REPORT UPDATE

Application No: LU/307/17/PL

LOCATION: Promenade Shelter
Sea Road

PROPOSAL: Demolition of promenade shelter & construction of cafe & kite surfing school with roof terrace & associated works

First floor plan | proposed

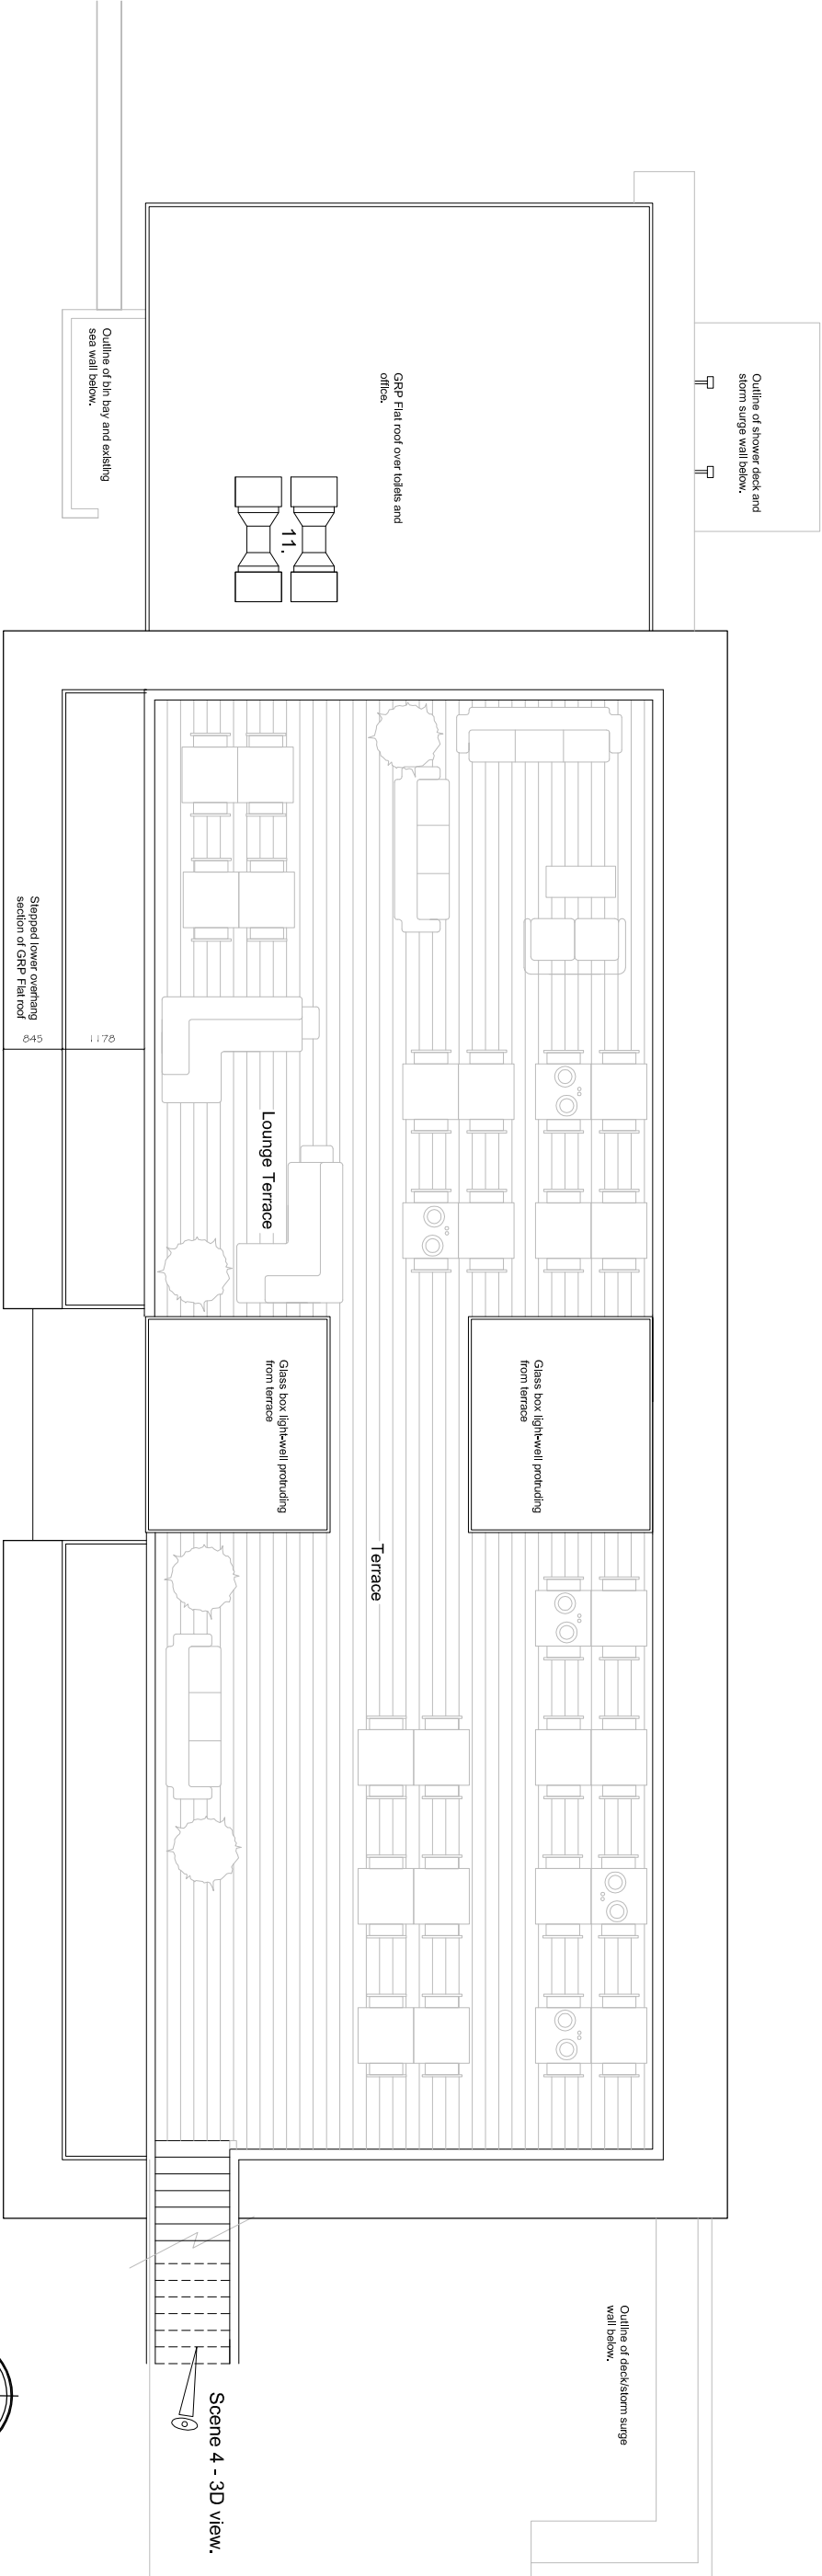
Substitute plans have now been submitted for consideration relating to the provision of a disabled platform to improve access to the upstairs seating area. The plans condition has been amended accordingly to refer to the substitute plans .

Concern that the information released does state that the building is 'subject to planning permission'. The design does not make adequate provision for wheelchair users to access the roof terrace and disabled toilet.

- Is the business viable?
- Could be relocated to the east.
- There are double yellow lines in front of the proposed development.
- Is there disabled access to the first floor so that everyone can enjoy the views?

Officer comment: Disabled access and emergency means of escape would be considered by building regulations. The proposal now incorporates a platform for disabled access to the upper floor which is compliant with Building Regulations. The toilets will be signed to clearly identify disabled provision and use by the general public.

Ground floor plan | proposed

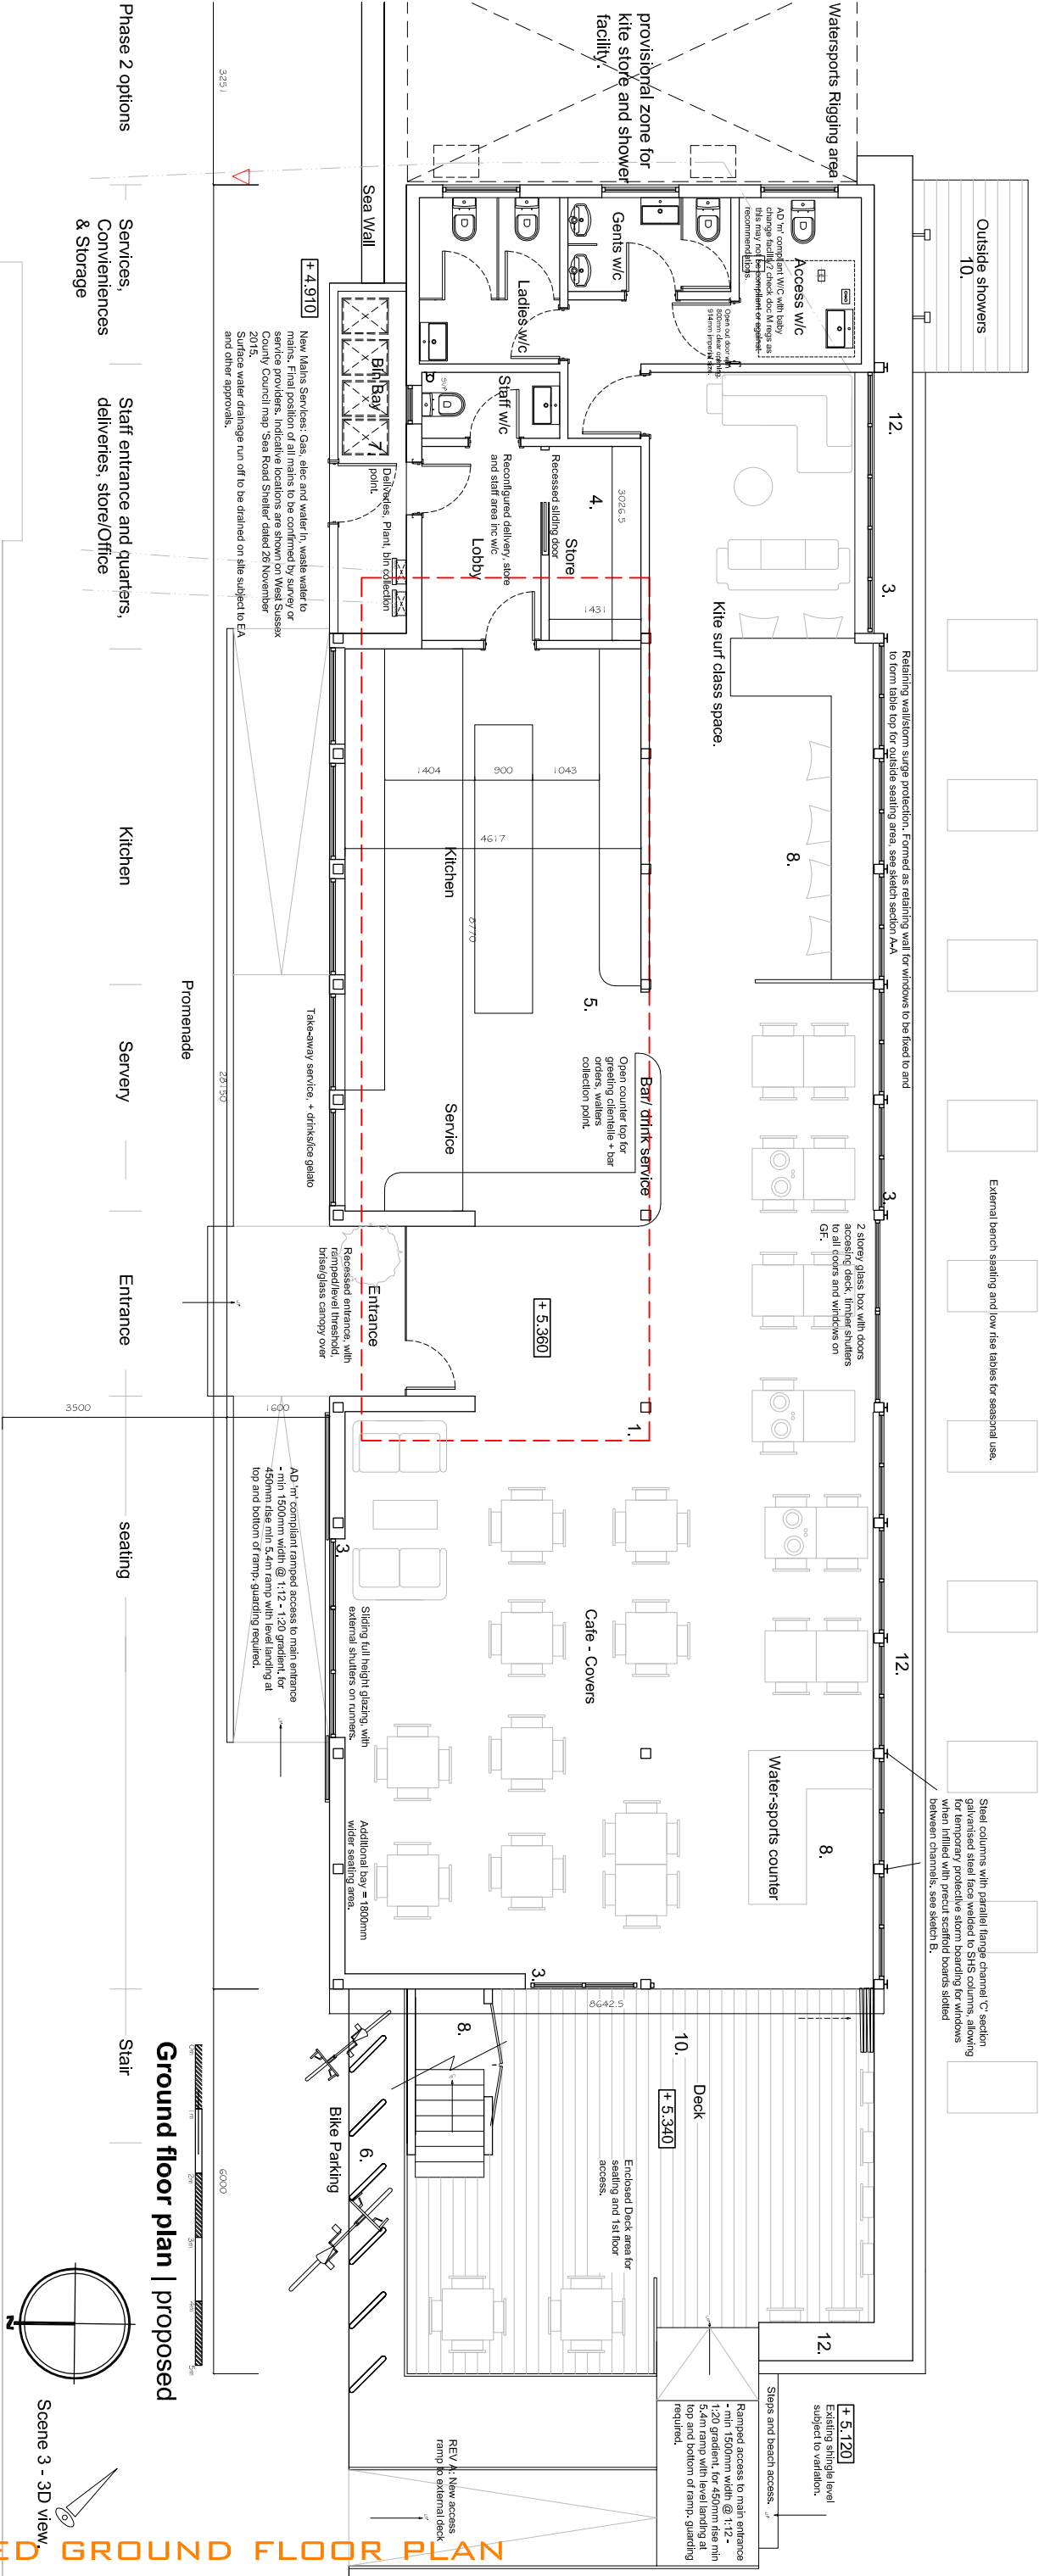
Access to the toilets for use by the public is through an area to be used for classes. It will not be very visible that the toilets are available for use by the public.

- Access to toilets is difficult.
- Proposal is not adapting to climate change. Location is unsuitable for development due to storm

- Access to toilets would meet the necessary building regulation requirements for disabled access.
- The proposal is adapting to climate change. The Flood Risk Assessment is acceptable to the Environment Agency. The applicant is aware of potential storm damage and flooding.
